Application number: 2020/92004	
What is the application for?:	Erection of two storey side and single storey rear extensions
Address of the site or building:	3, Reinwood Avenue, Quarmby, Huddersfield, HD3 4DP
Postcode:	HD3 4DP

Type of comment: An objection

Drawing Title_
AS PROPOSED PLANS + ELEVATIONS

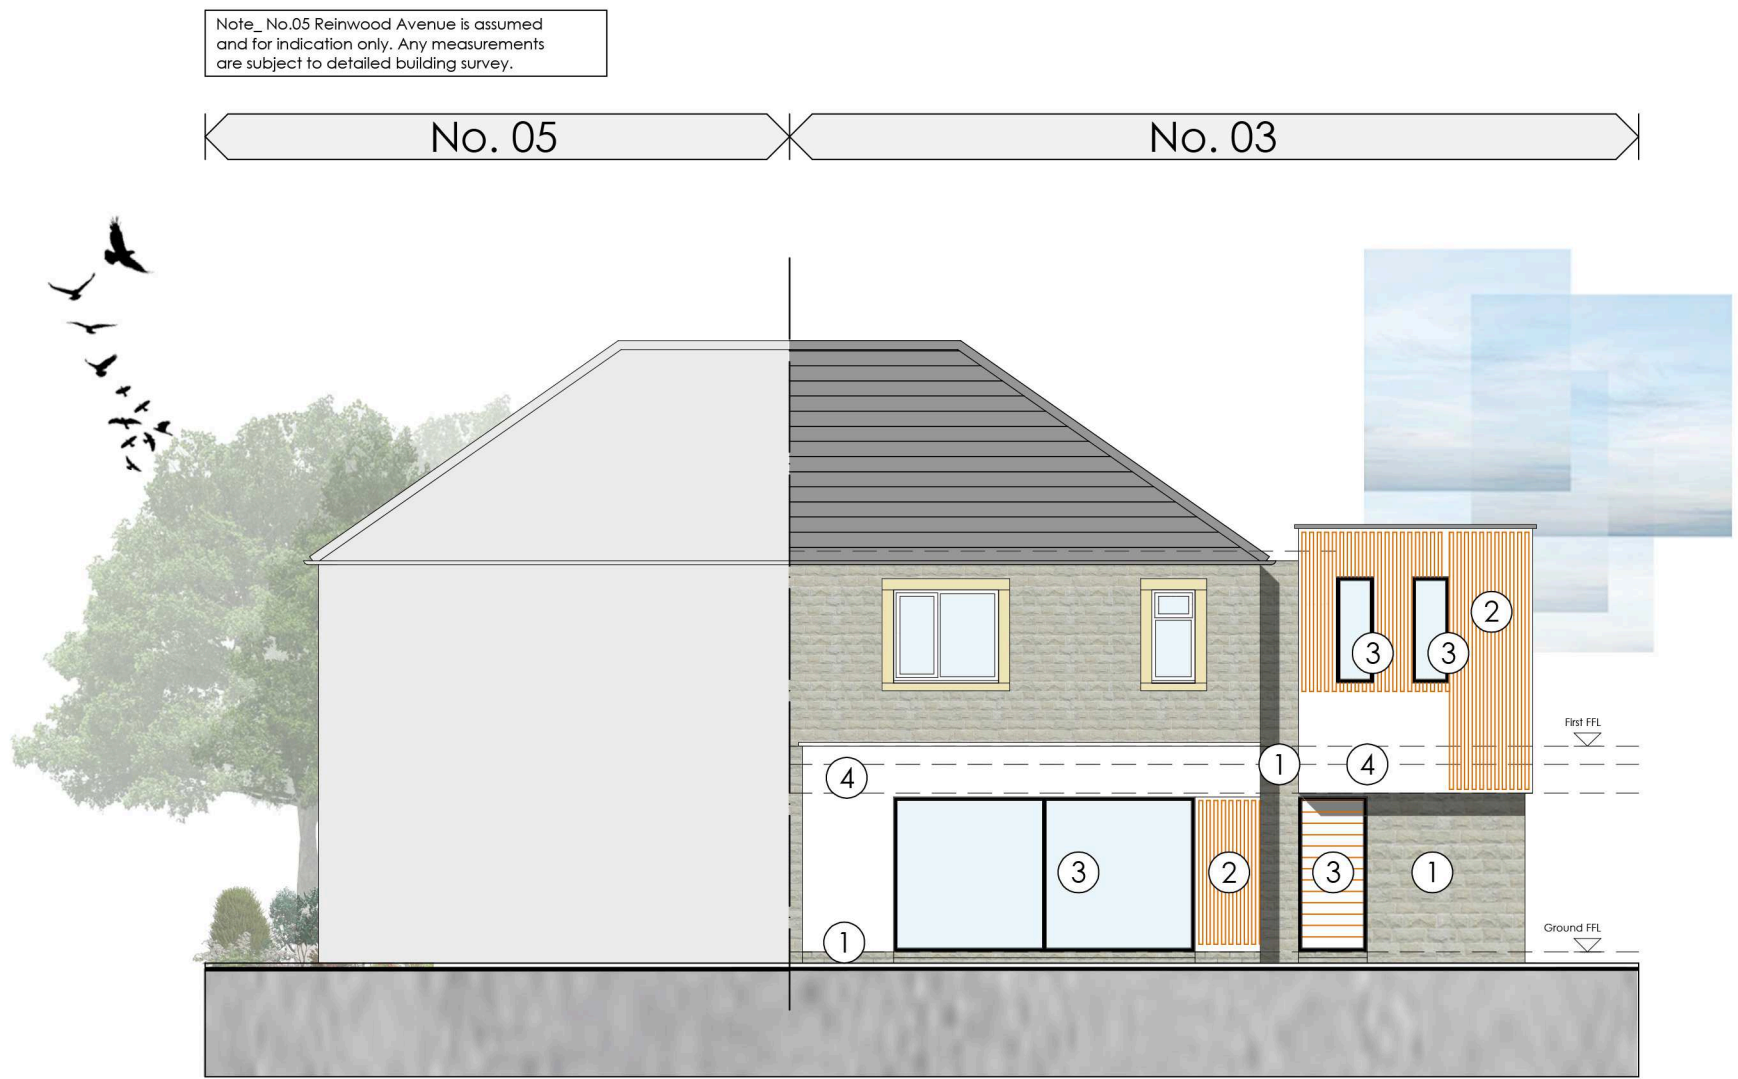
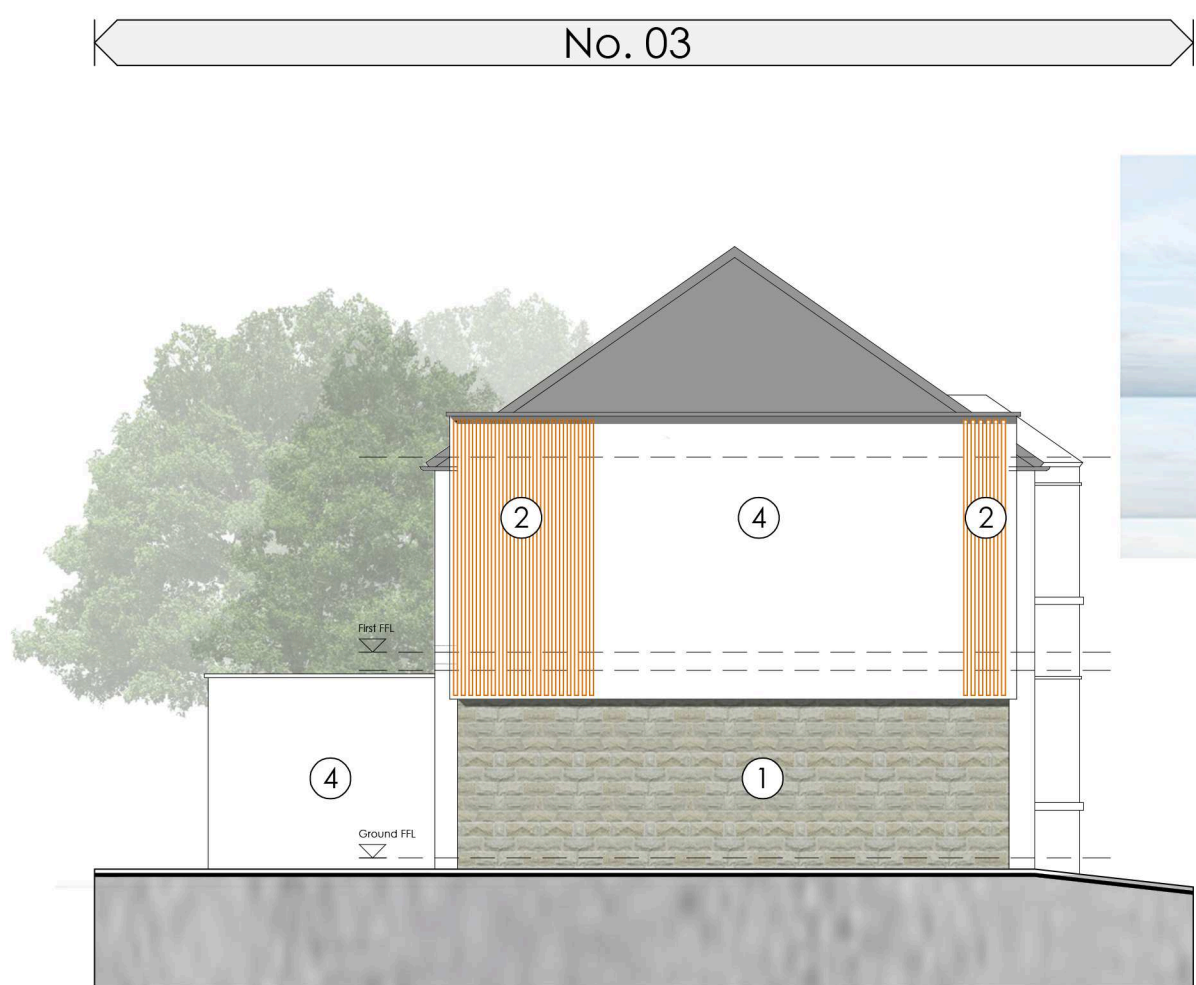
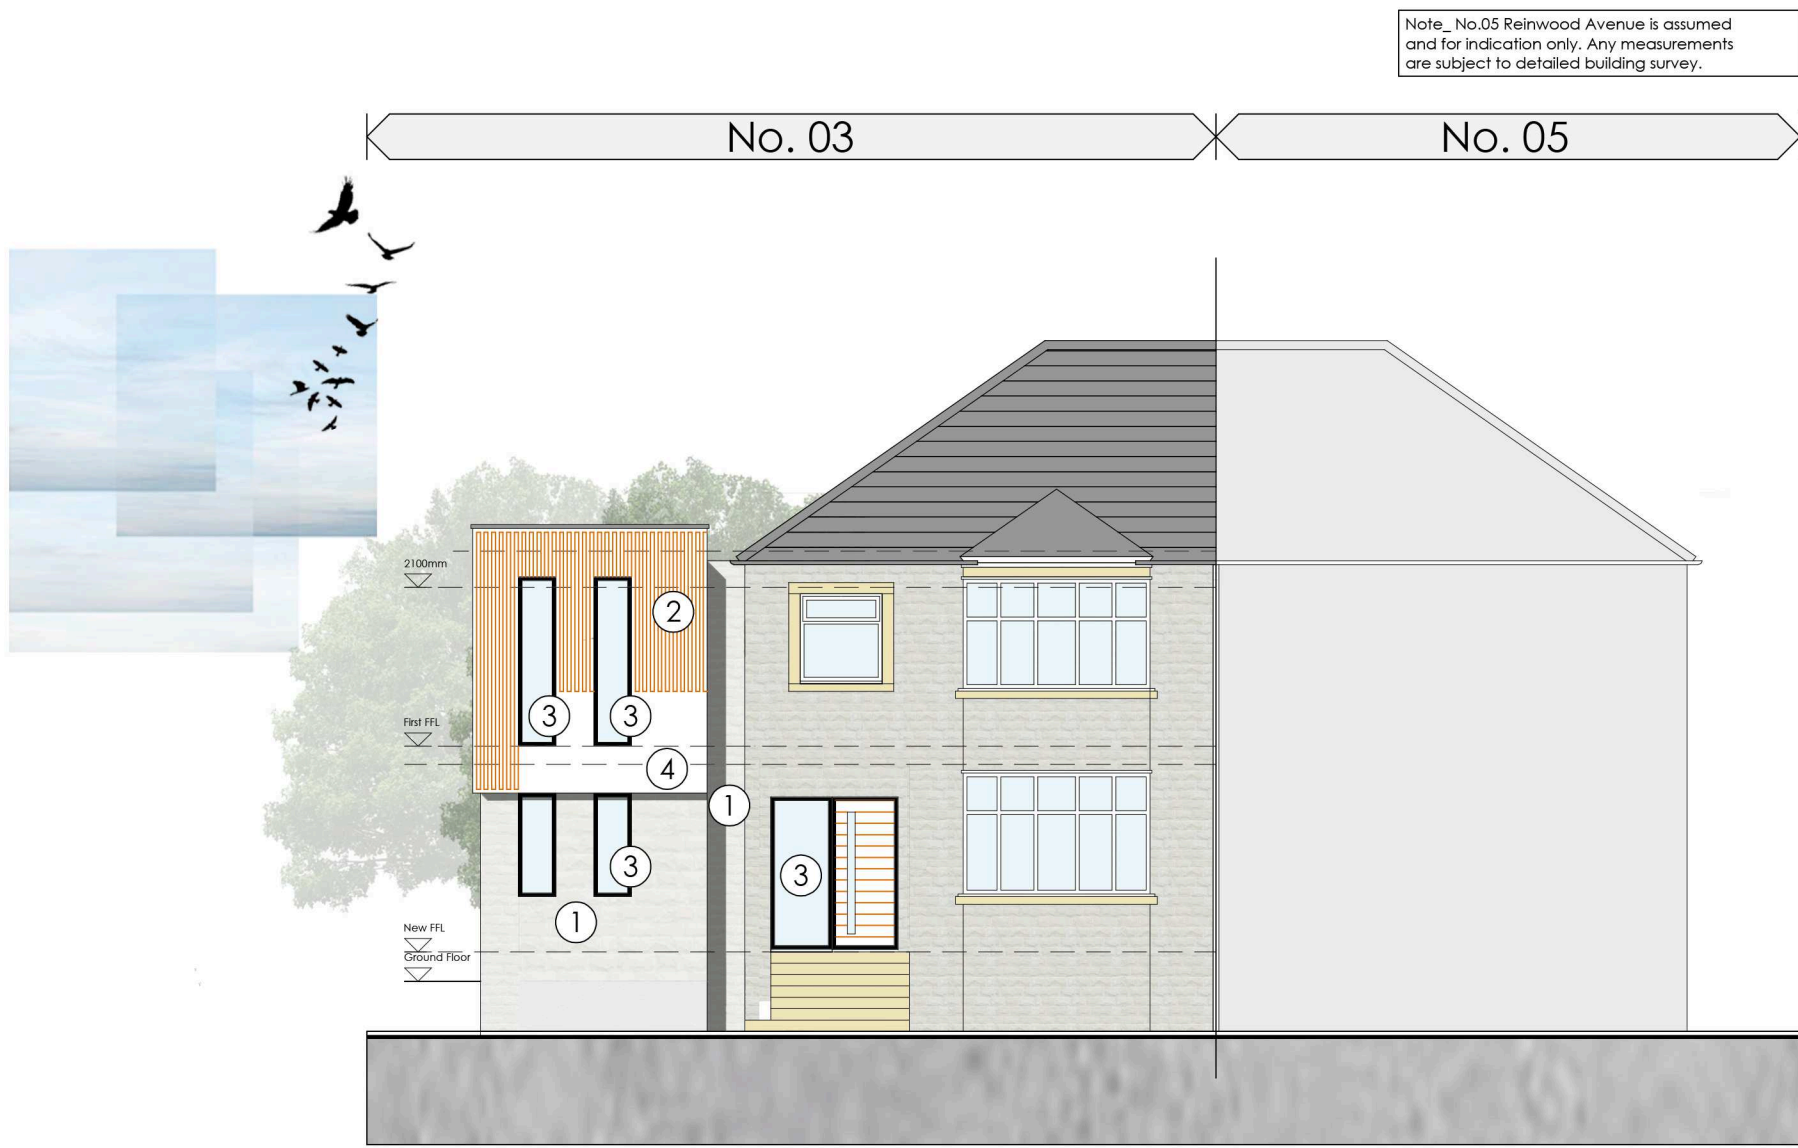
- We are primarily concerned over the choice of design and style of materials proposed, these not being in keeping with, and quite significantly different to the original property and character of neighbouring buildings.

- Distinguishing between old & new is not necessarily an issue, but the large difference between the two styles is concerning and we fear it would appear 'jarring' next to the original part of the property, and not be in keeping with the streets' character. The flat roof in particular has no precedent.

- We do not object to modern styling in principle, so long as it is sympathetic to the old frontage, however the drawings at present do not give us this confidence.

- A more traditional (or sympathetically blended) frontage and roofline with a modern side and rear aspect would be a suitable compromise.

- The new extension will be very visible from the street and from all properties that look onto it, particularly due to its elevated height from the road and other properties.

(Please note if relevant: the architect drawings have not accounted for the extended size of no.5 relative to no.3 in their drawings so these are not to scale for the adjoining property.)
